Re: City Plan Review Comments for Building Code Conformance - Permit 2012-199 Merlino Residence

Page 2 comment - Don Cole

**UPPER LEVEL FLOOR FRAMING**

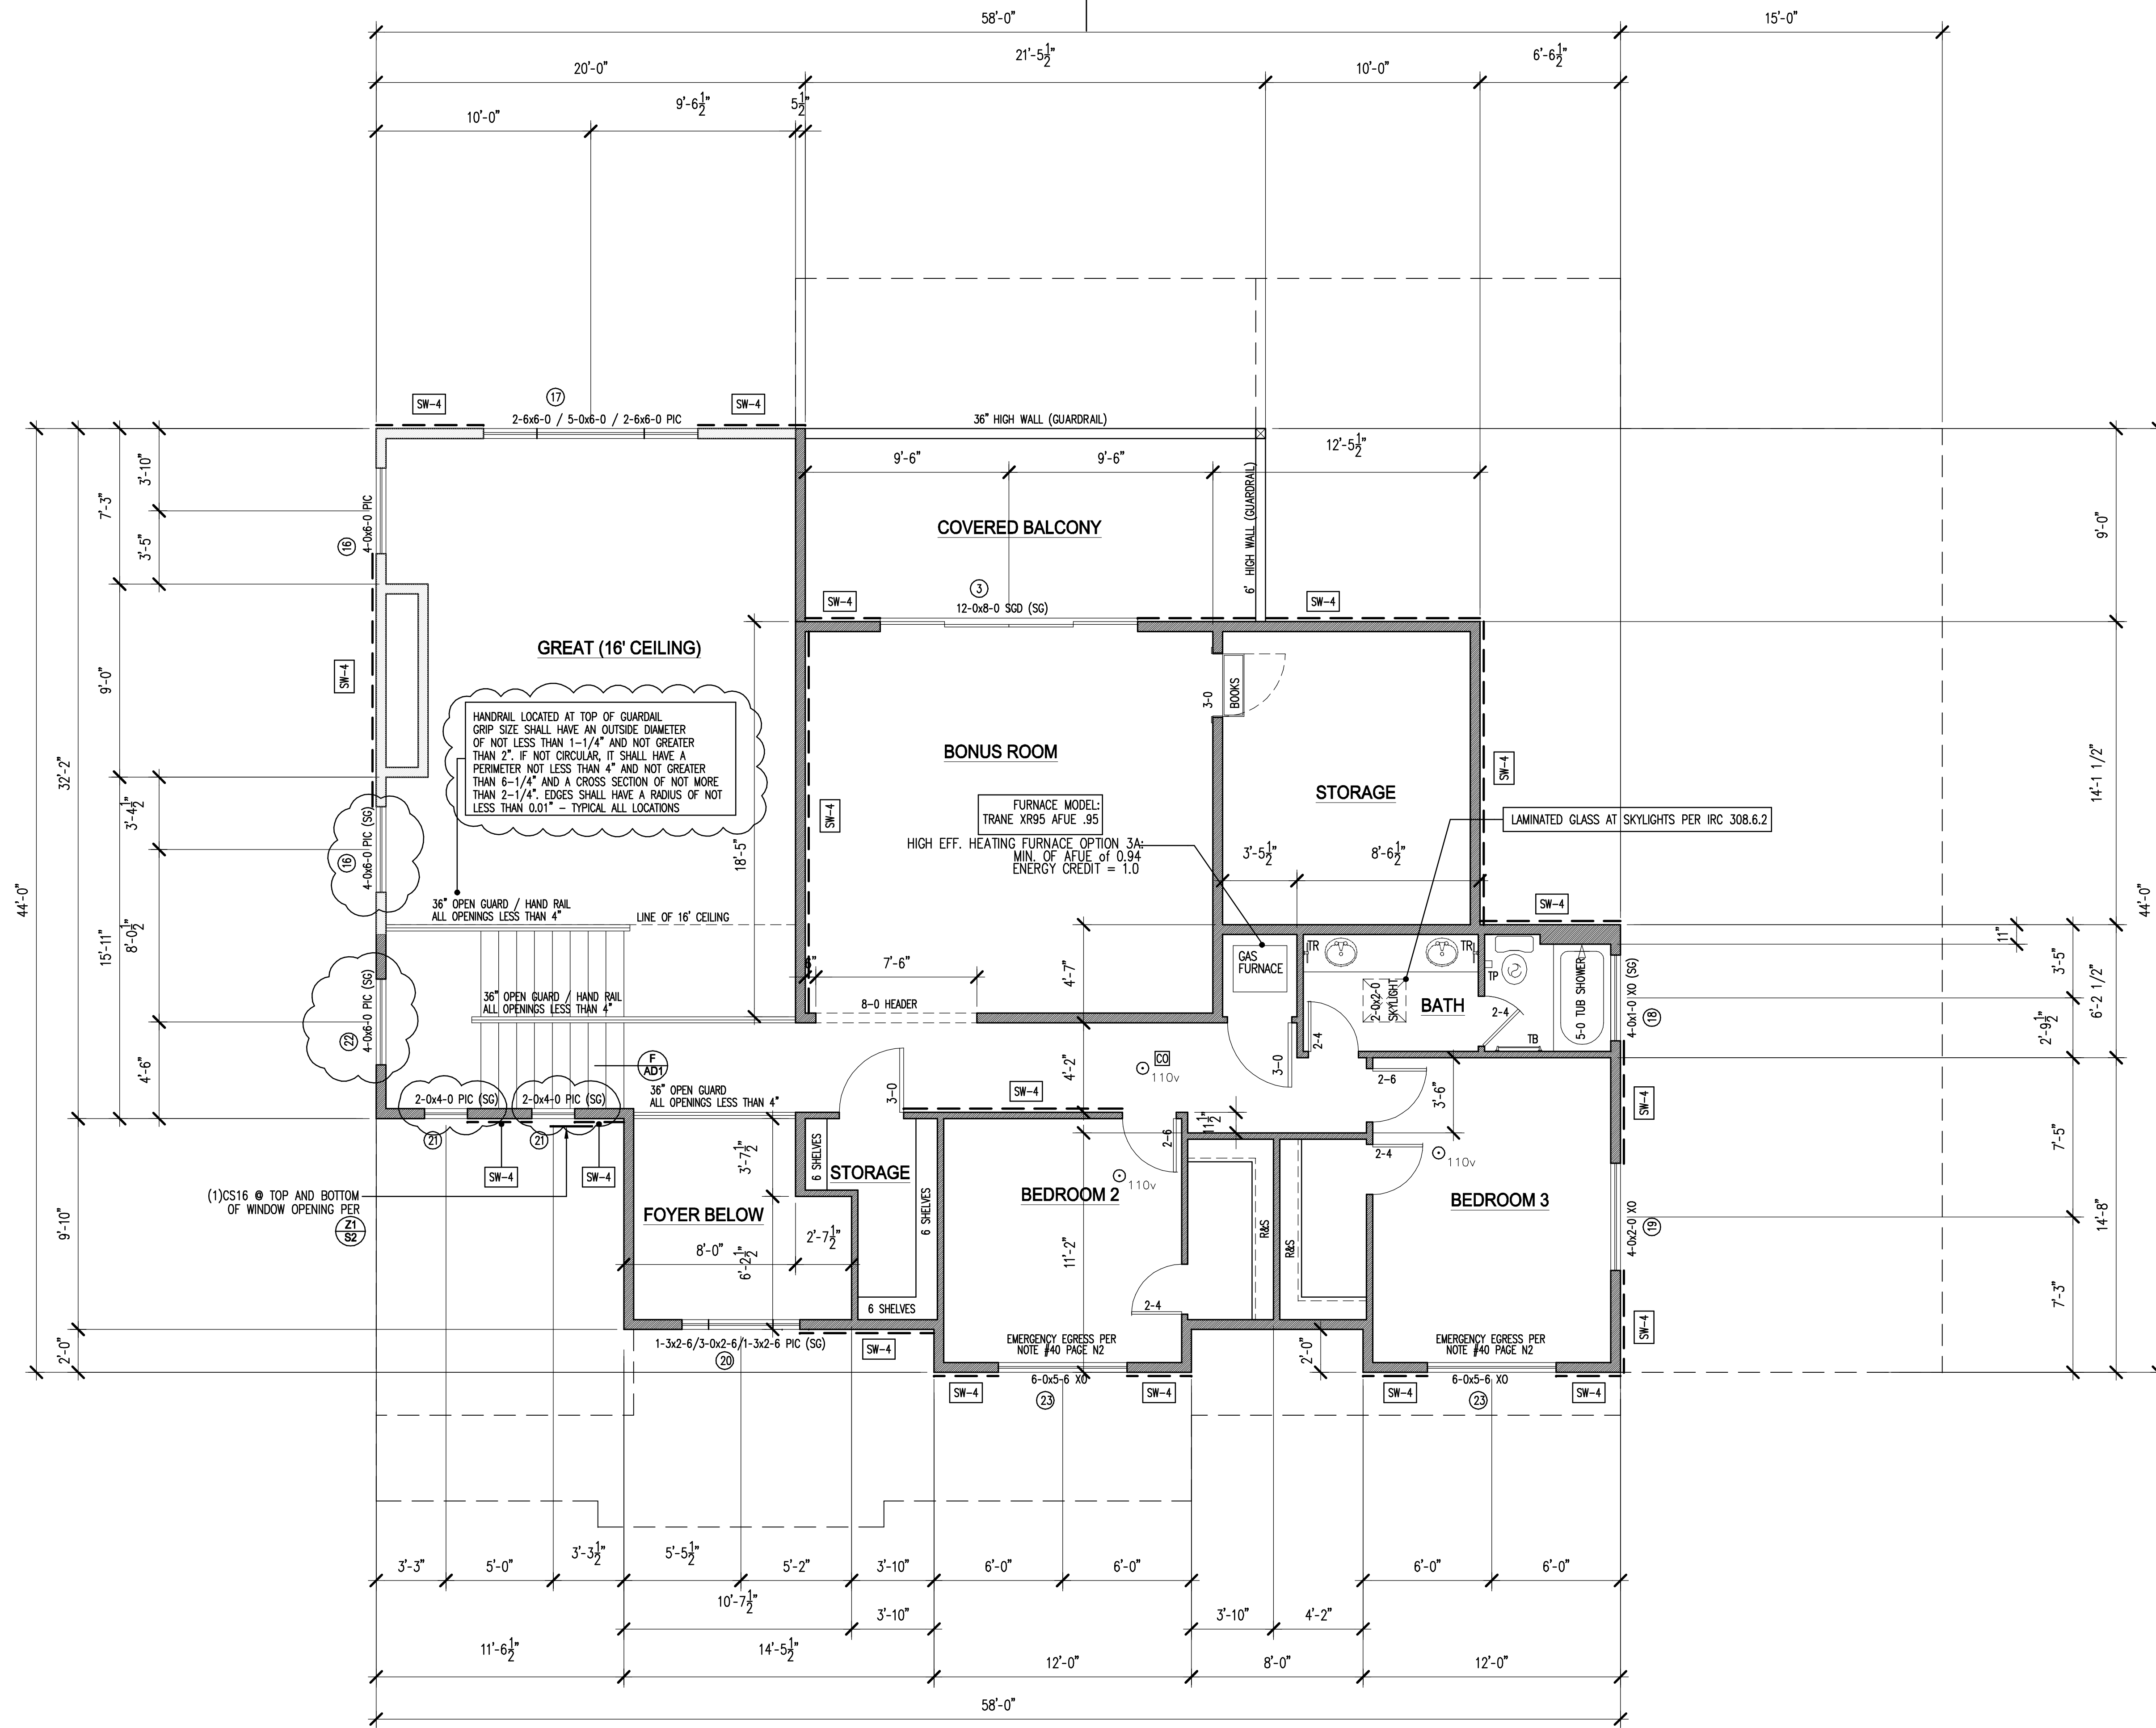
Ross - this is the hot one for the Merlino's that I told you about on the phone. I bubbled the added structure under the bearing wall that is the wall between the laundry and mudroom, up the master door. I also added the blocking under the perpendicular shear wall and called out detail L. Don Cole also had a comment about the Kzt value, item 1. Can you jump on this one?

- 2. Show blocking between joists beneath bearing wall above and provide calculations to show adequacy of joists to support tributary roof, wall, upper floor and lower floor loads.

THANKS FOR THE CORRECTION, PLEASE SEE CALCS PROVIDED
